From: Mark Warwick
Sent: 03 October 2018 13:16
To: Simon Davis
Cc: Planning.Responses
Subject: FP/171/18/PL

Planning Application Ref: FP/171/18/PL

Location: Land at Stanhorn Grove, Felpham

Description of works: Erection of 18 No. dwellings, creation of new access, landscaping & associated works

The final scheme is shown on this page.

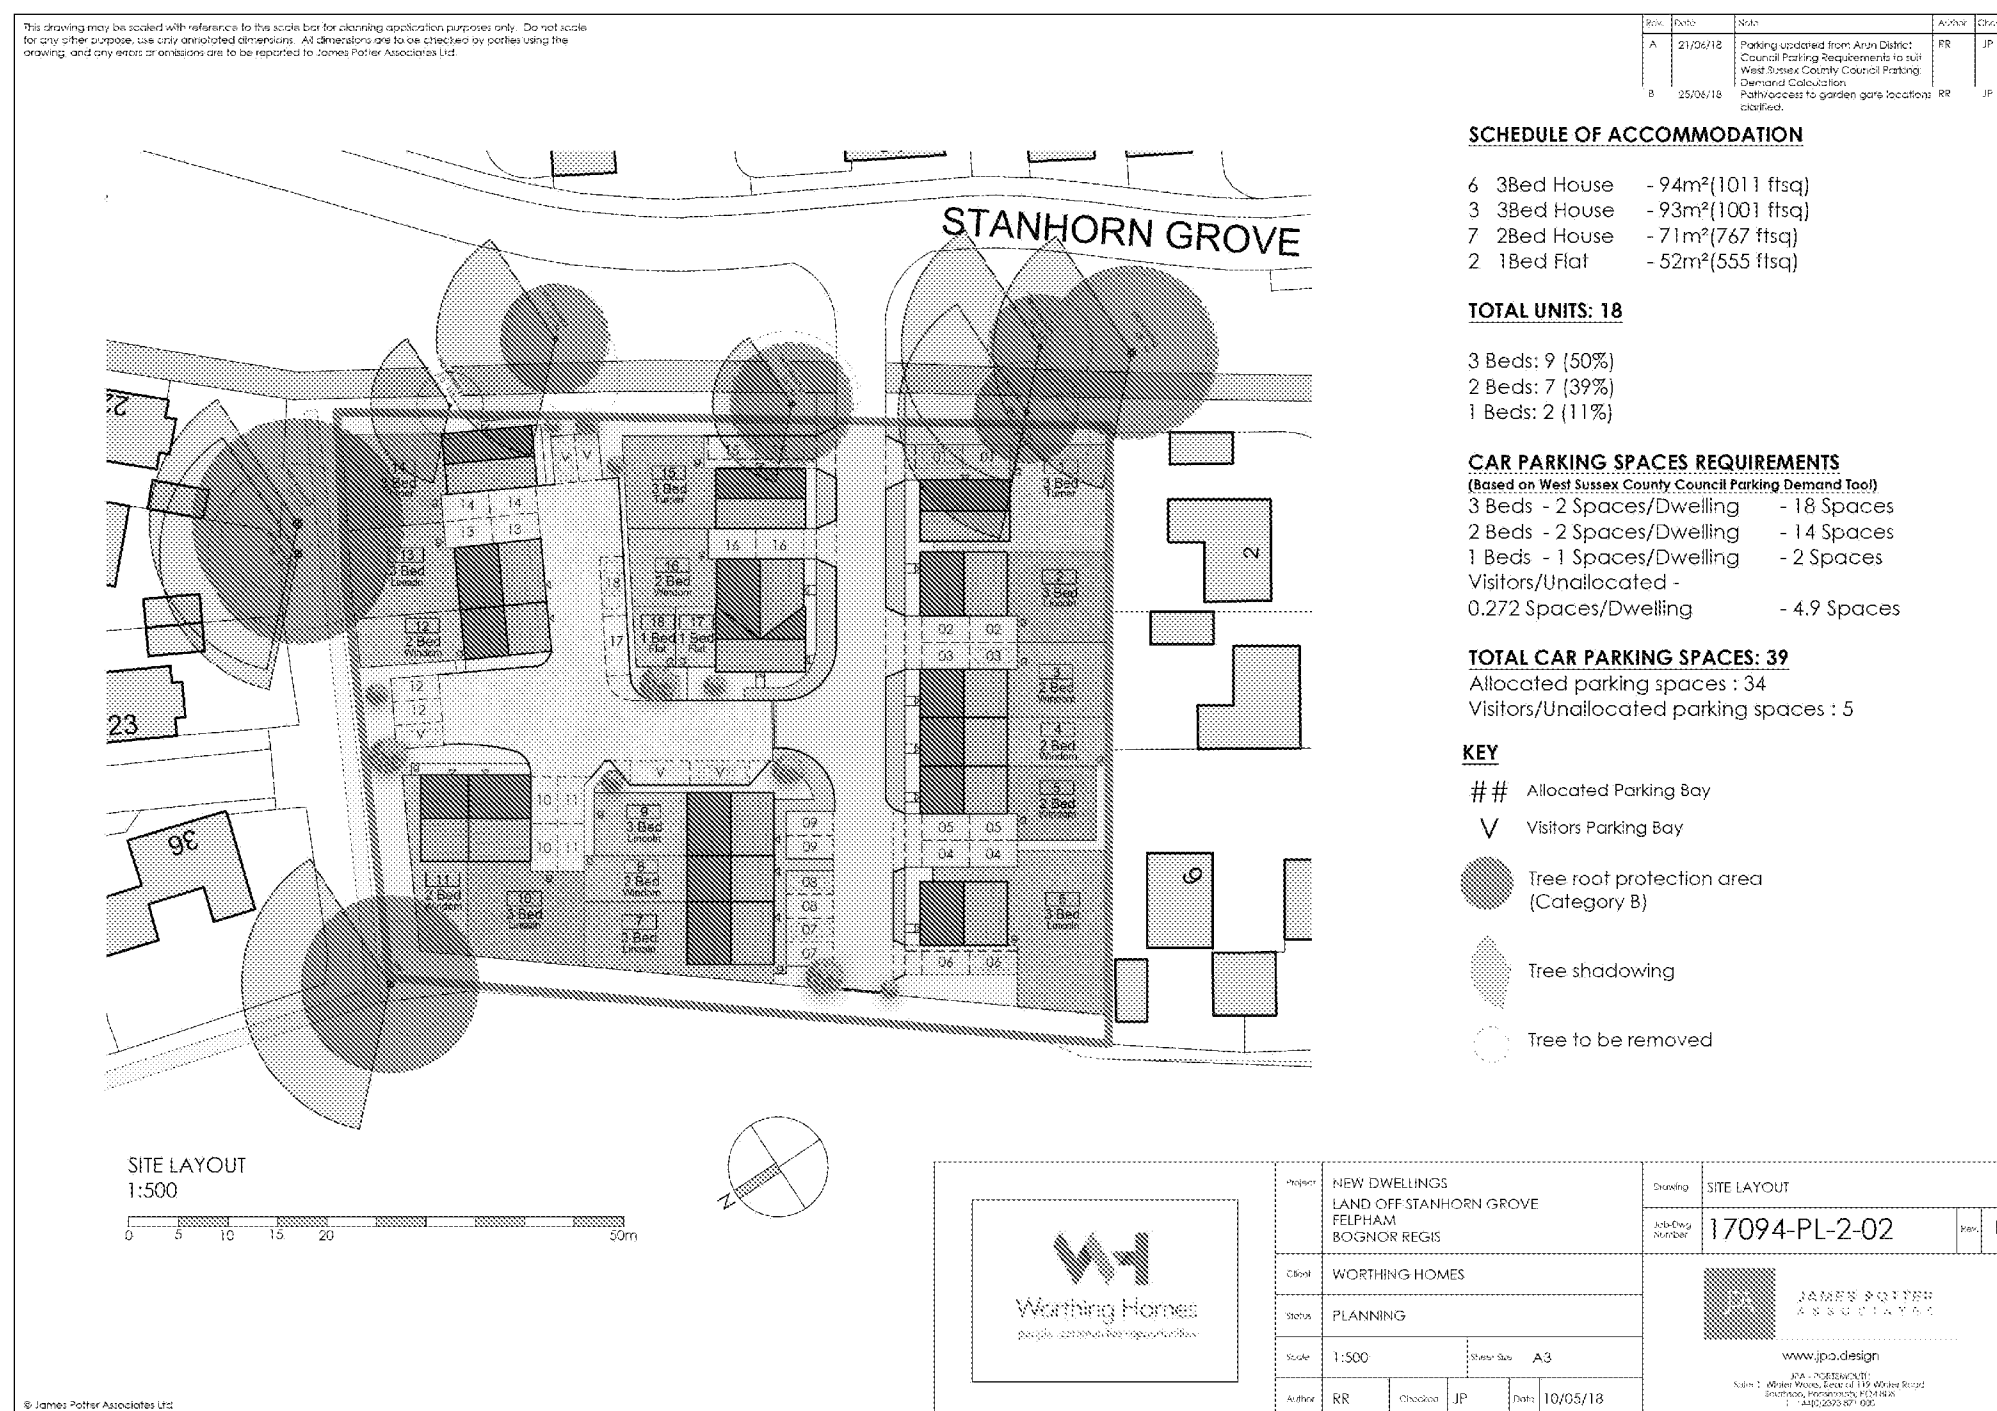
- The latest site layout proposes significant RPA incursion from the construction of driveway/parking areas and main estate access road from the east and/or does not allow for future growth - in respect of oak trees T7, T8 and T11.

- 'Pressure to prune' trees along the east boundary from future residents of plot number 1 should be anticipated, putting at risk the public amenity value they currently provide. A revised layout should be sought that better accommodates existing trees of significant value (T1, T3 and T7).
